To: Mike McCarthy, El Paso County Public Health
From: Andrew W. McCord, P.E.
Date: April 30, 2019
Project: CSPD Firing Range
Subject: Colorado Springs Police Department Weapon Range, PPR-10-043

The following are our responses to the comments by El Paso County Public Health, Environmental Health Division on the proposed Colorado Springs Police Department Weapon Range.

C-106

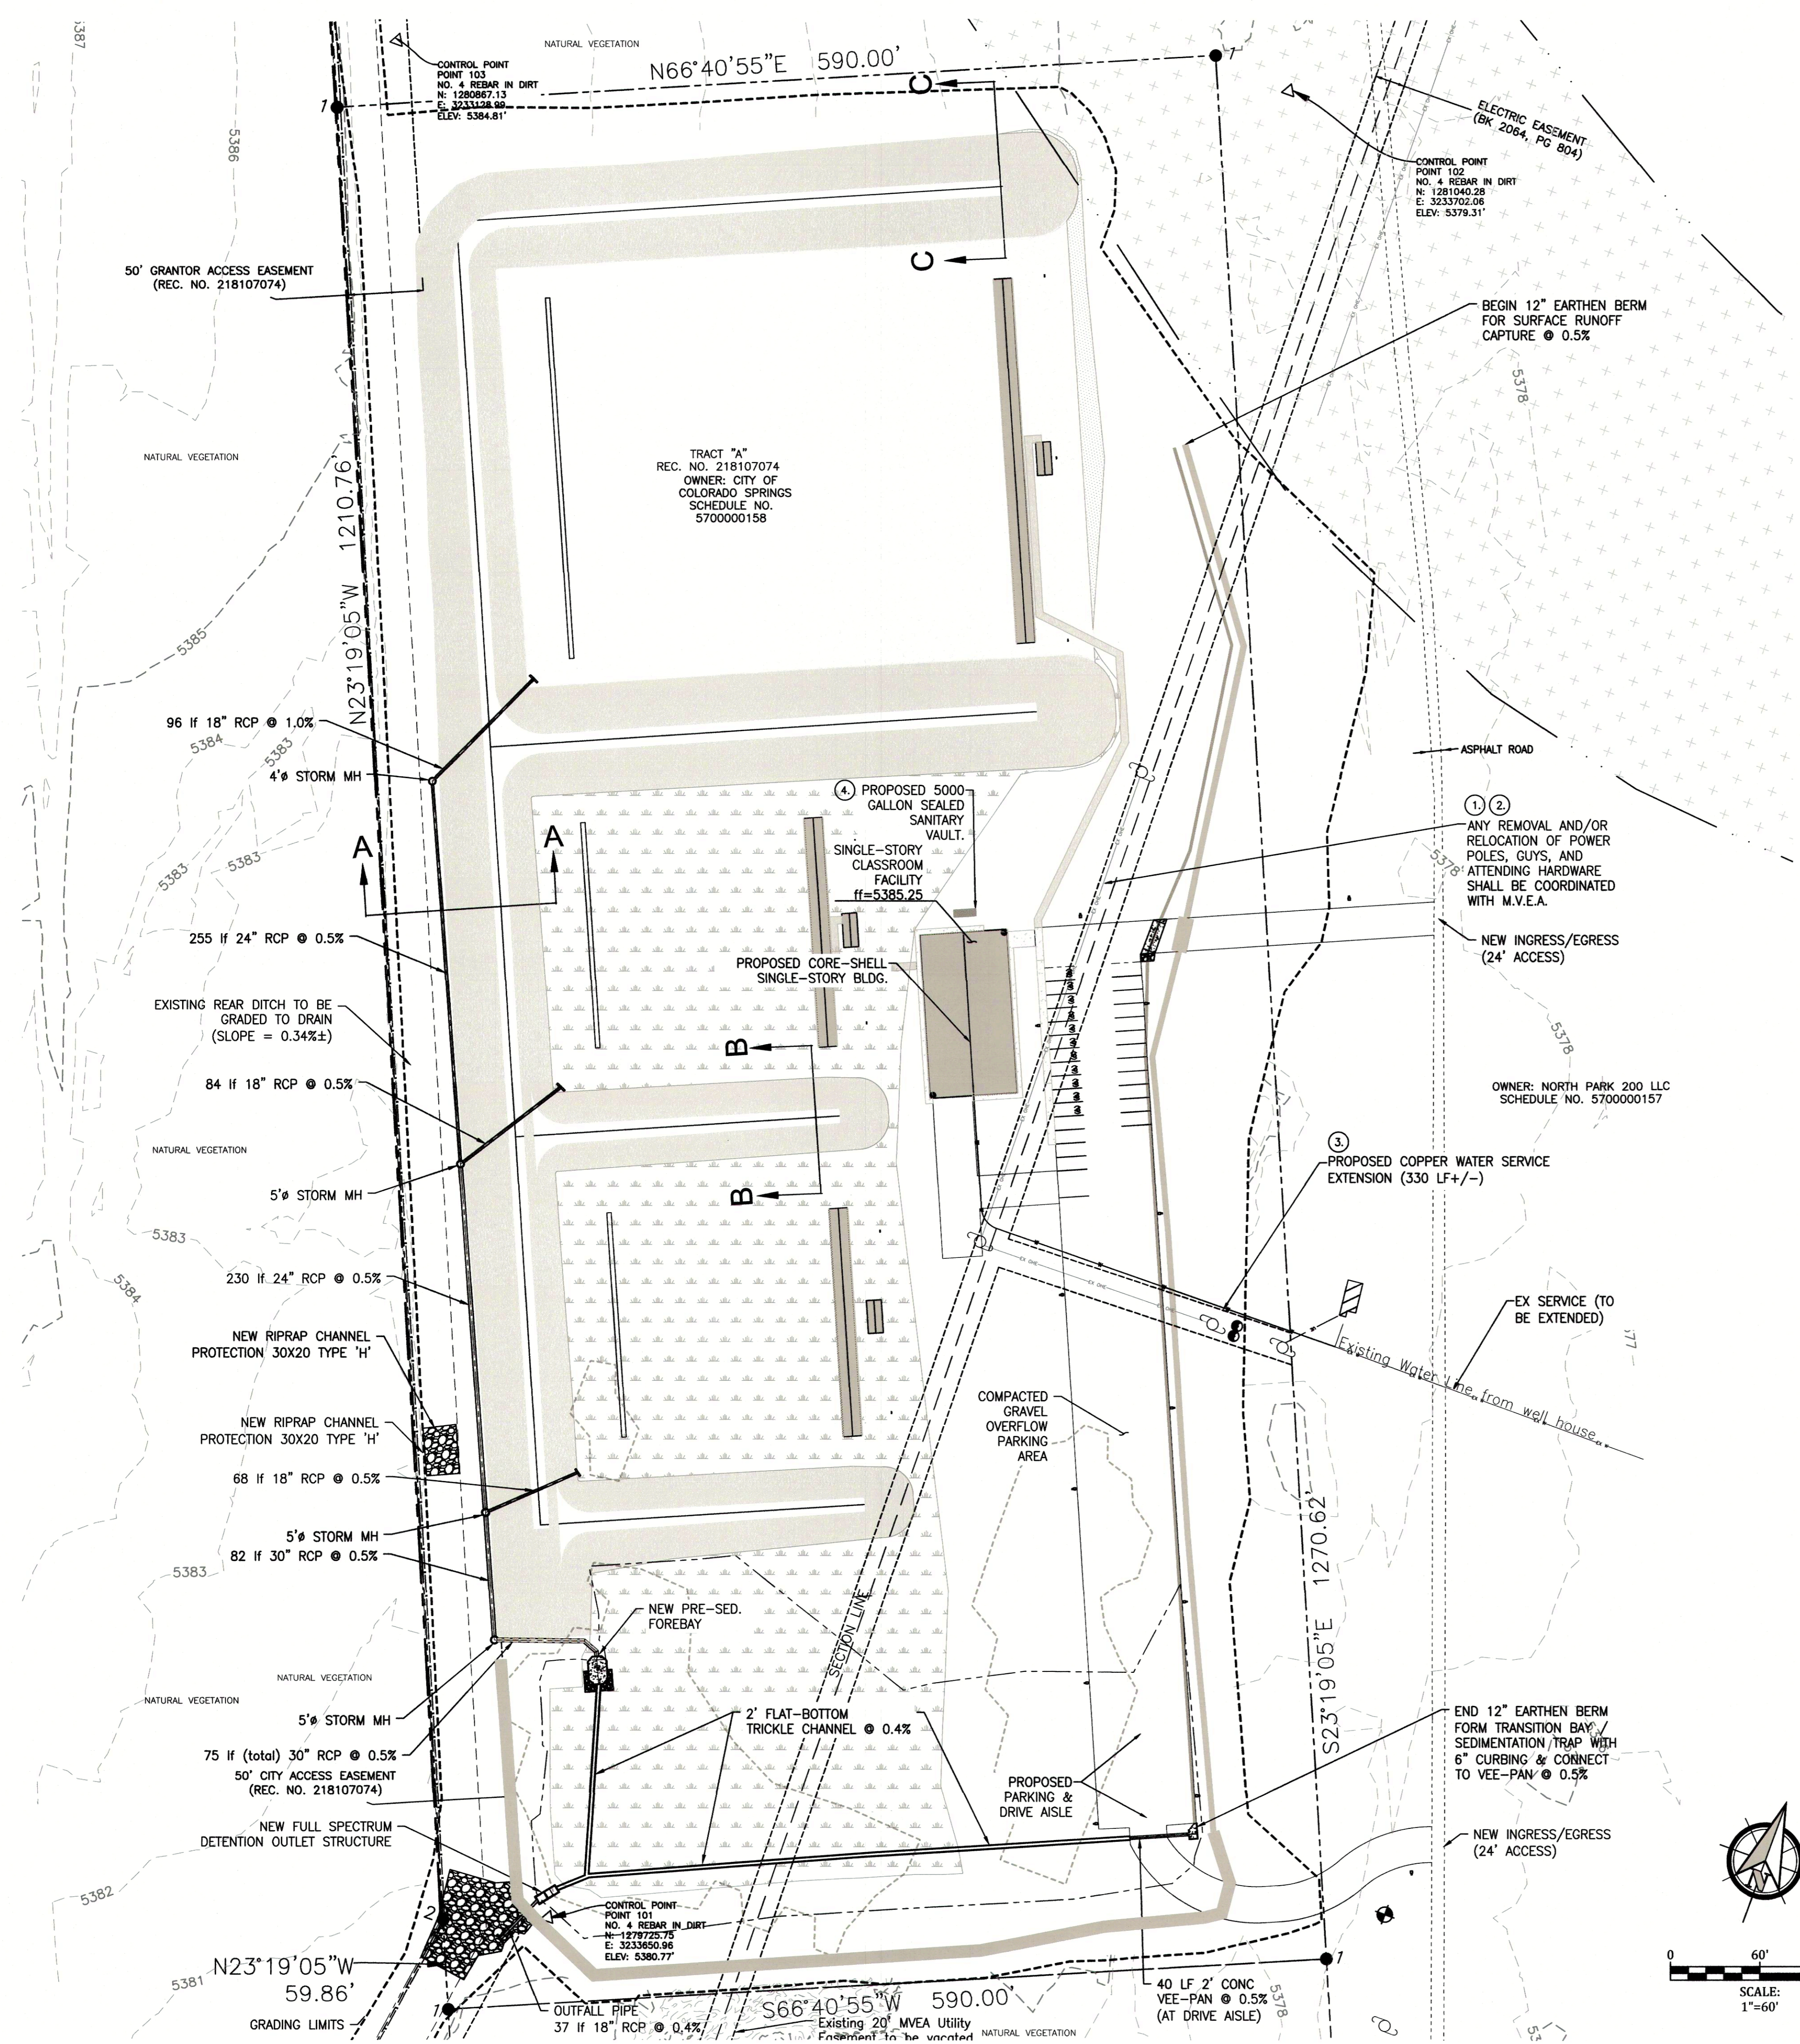
An audible alarm indicating full capacity condition of the 5,000-gallon holding tank has been indicated as required on the Utility Plan (Sheet C-107).
